City of Portland, Maine - Building or Use Permit Application
 389 Congress Street, 04101 Tel: (207) 874-8703, Fax: (207) 874-8716

Permit No: 09-0853	Issue Date:	CBL: 267 A007001
------------------------------	--------------------	----------------------------

Past Use: Commercial	Proposed Use: Commercial / Burger King: Install 297.30 sq. ft. of signs, and five metal awnings.	Permit Fee: \$624.60	Cost of Work: \$0.00	CEO District: 3
Proposed Project Description: Install 297.30 sq. ft. of signs, and five metal awnings.		FIRE DEPT: <input type="checkbox"/> Approved <input type="checkbox"/> Denied	INSPECTION: Use Group: Type	
		Signature:	Signature:	
PEDESTRIAN ACTIVITIES DISTRICT (P.A.D.)				
Action <input type="checkbox"/> Approved <input type="checkbox"/> Approved w/Condition <input type="checkbox"/> Denied				
Signature:		Date:

Dept: Zoning	Status: Approved with Conditions	Reviewer: Ann Machado	Approval Date: 08/21/2009
Note: Existing nonconforming freestanding sign - will be 12' diameter & 78' high (can't be higher than new freestanding sign (BK & reader board) 80.27 sf 3 building signs - Riverside Street (BK & letters) 47.51 sf - Larabee Street (BK) 28.26 sf - back side (BK) 28

137 Riverside
Existing sign

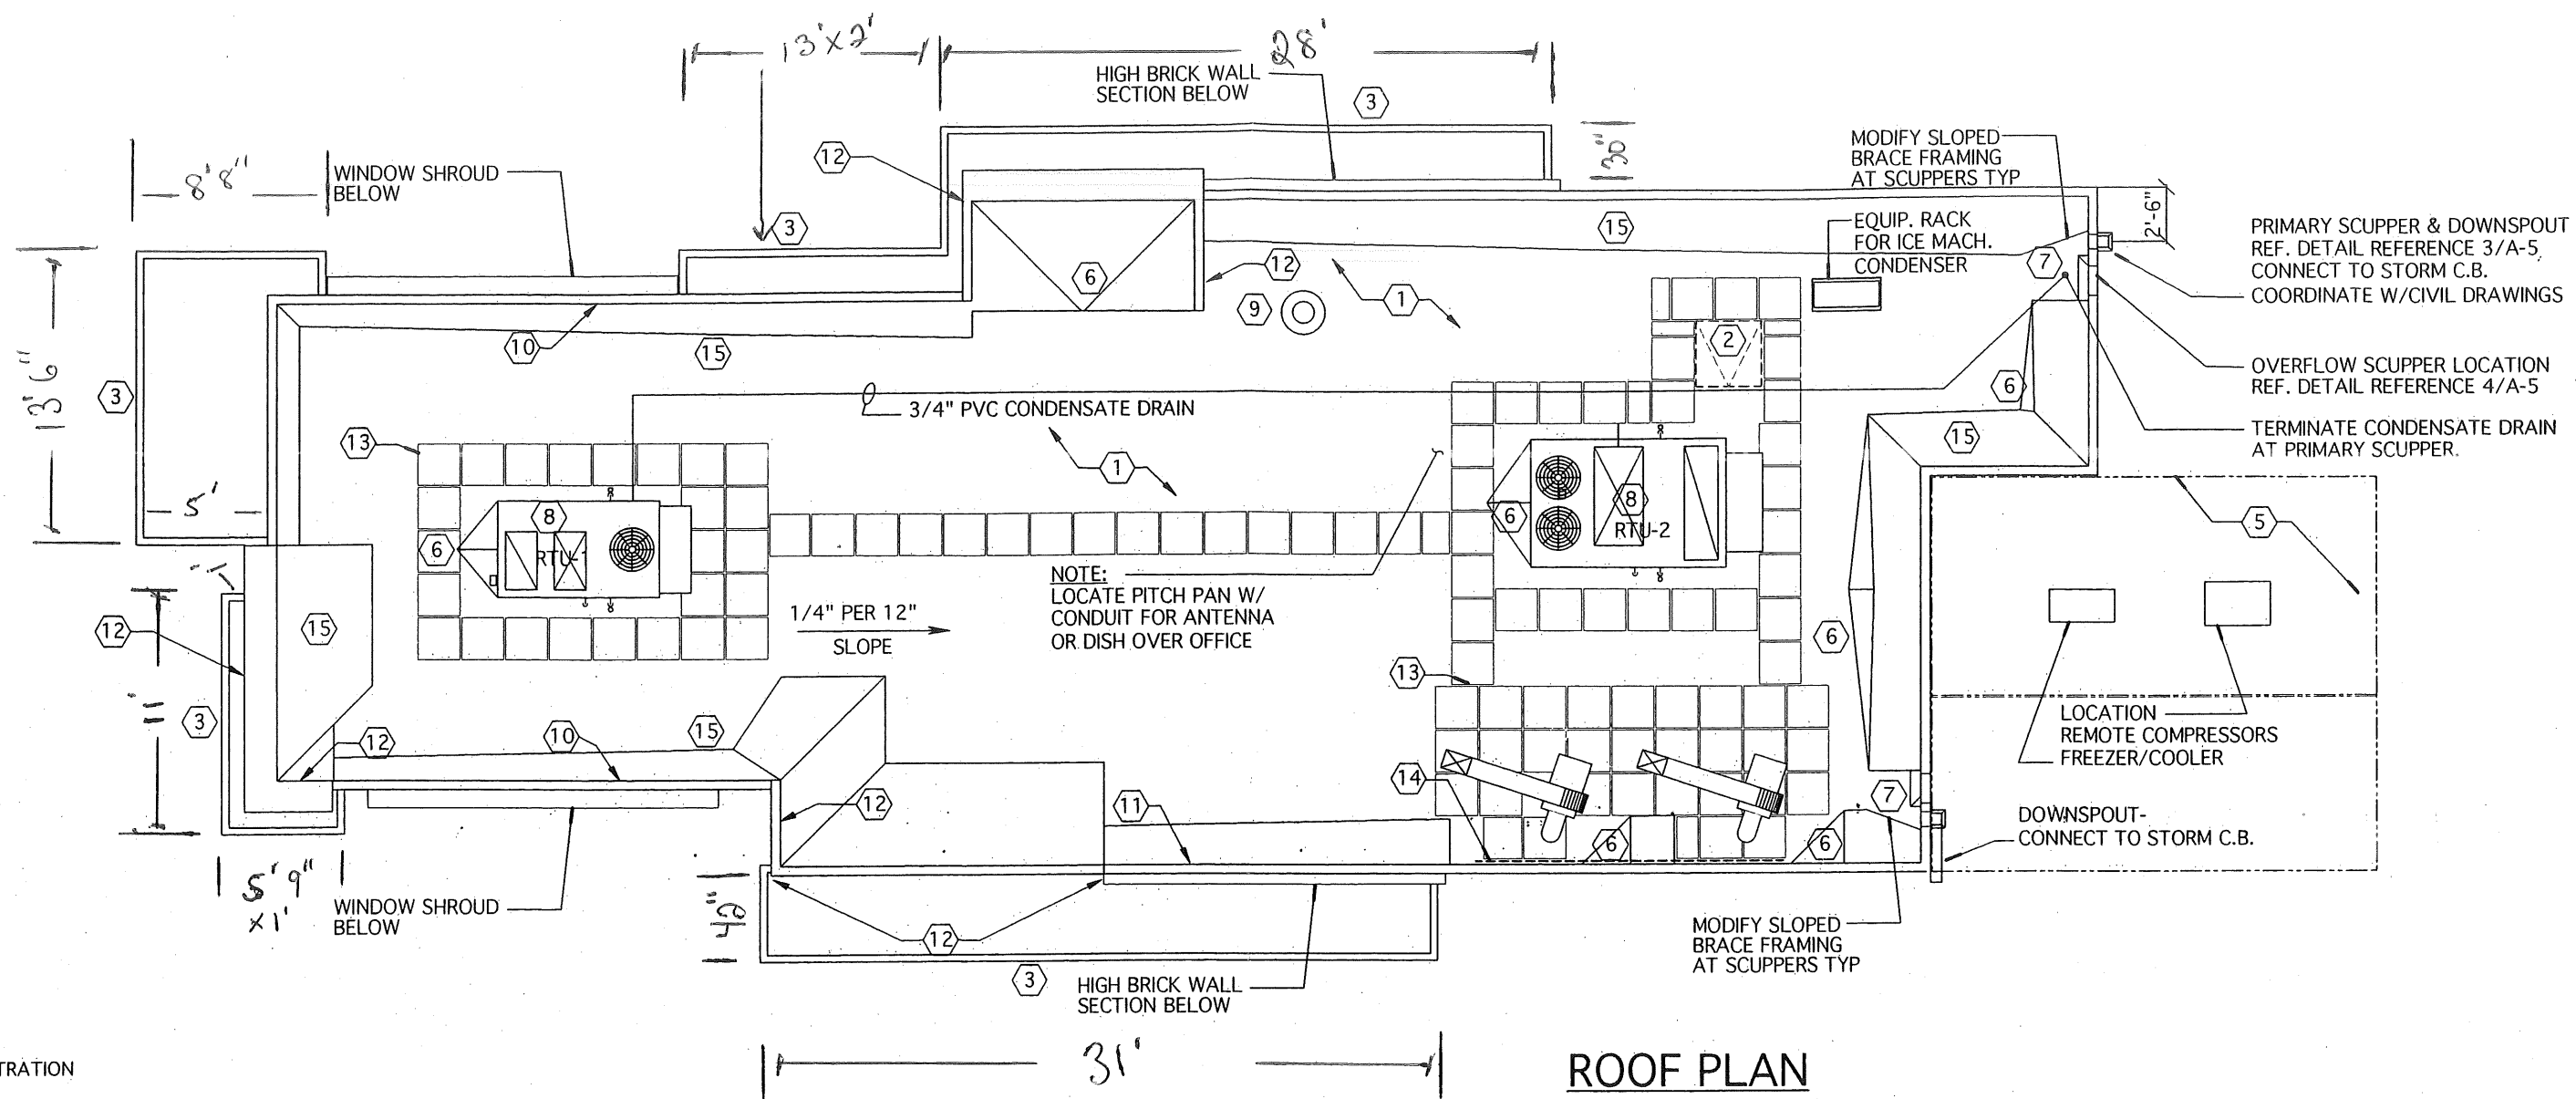
Comments:
8/20/2009-amachado: Spoke to Marc Rochon. Don't have the information on the awnings. Need more information on the existing non conforming freestanding sign. Needed to confirm the size of the BK Circle in the new freestanding sign.
8/21/2009-amachado: Received information on awnings and information on existing freestanding sign. Still need information on how the new sign will be attached to the existing poles. Moving permit forward because zoning is all set.
